Date: 03 May 2019
Our ref: 279225
Your ref: TR020002

NSIP Reference Name / Code: Manston Airport / TR020002

**Natural England's submission for Deadline 6:
Answers to the Examining Authority's second written questions (ExQ2)
Comments on the Applicant's responses to Written Representations [REP4-025]**

Comments from Natural England on the Ecology Noise Contour Maps submitted by the Applicant at Deadline 4 [REP4-018]

Figure 7 7
Annual mean NO_x process contribution (excluding roads) in Year 20 with SSSI units

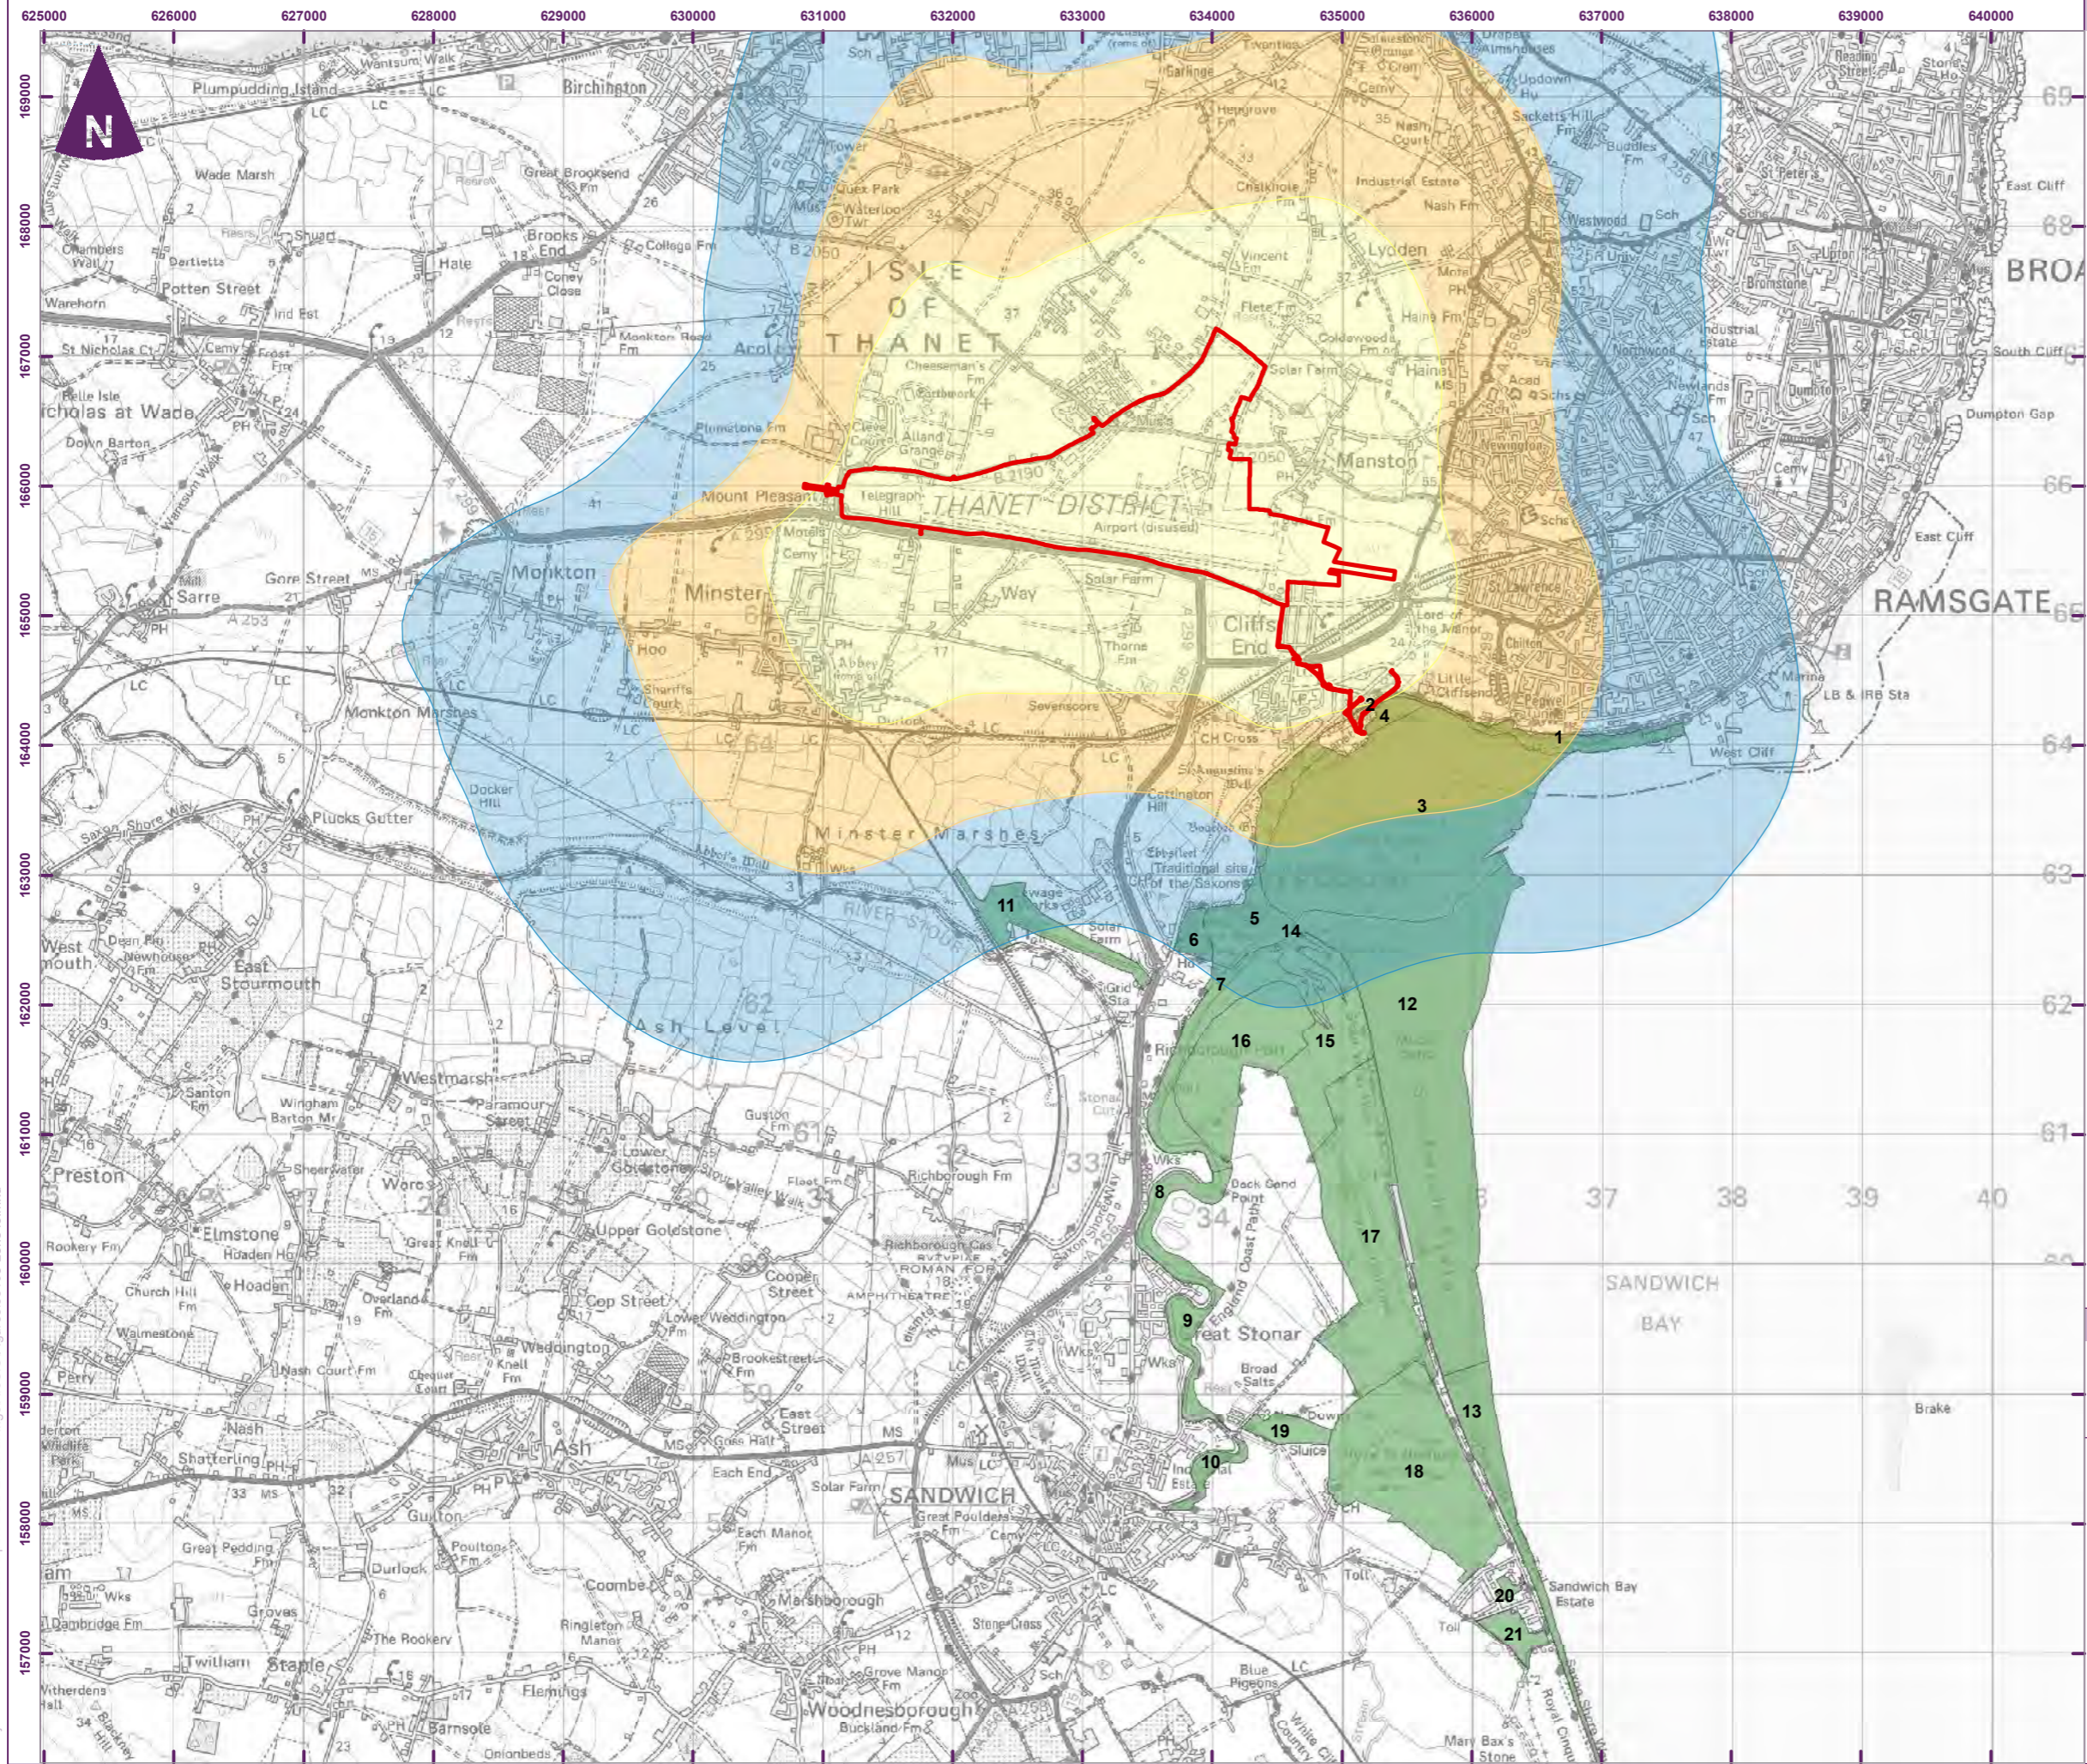
In paragraph 3.4.7 of our Written Representation, Natural England suggested it would be useful if the contour plots were able to demonstrate the overlap between road and air sources, and also for the contour plots to clearly show where the Process Contribution of NO_x is more than 1% (or relevant proxy) of the Critical Level where the background is at or over 100%. We note the Applicant's comments with regard to contour plots for roadside air quality impacts. It would be helpful but is not essential to produce contour plots for roadside locations. However, the contour plots for the airport alone, also do not clearly show where the Process Contribution of NO_x is more

than 1% (or relevant proxy) where the background is at or over 100% of the Critical Level. This would clearly illustrate the areas of habitat that are discussed within Chapter 7 [APP-033] in relation to the potential effects on designated sites. We request that this information is submitted when the amended air quality information is submitted.

- c) Contour plots to clearly show where the Process Contribution of NO_x is more than 1% (or relevant proxy) where the background is at or over 100% of the Critical Level. This should be overlain with habitat data to clearly illustrate the potential effects on designated sites.
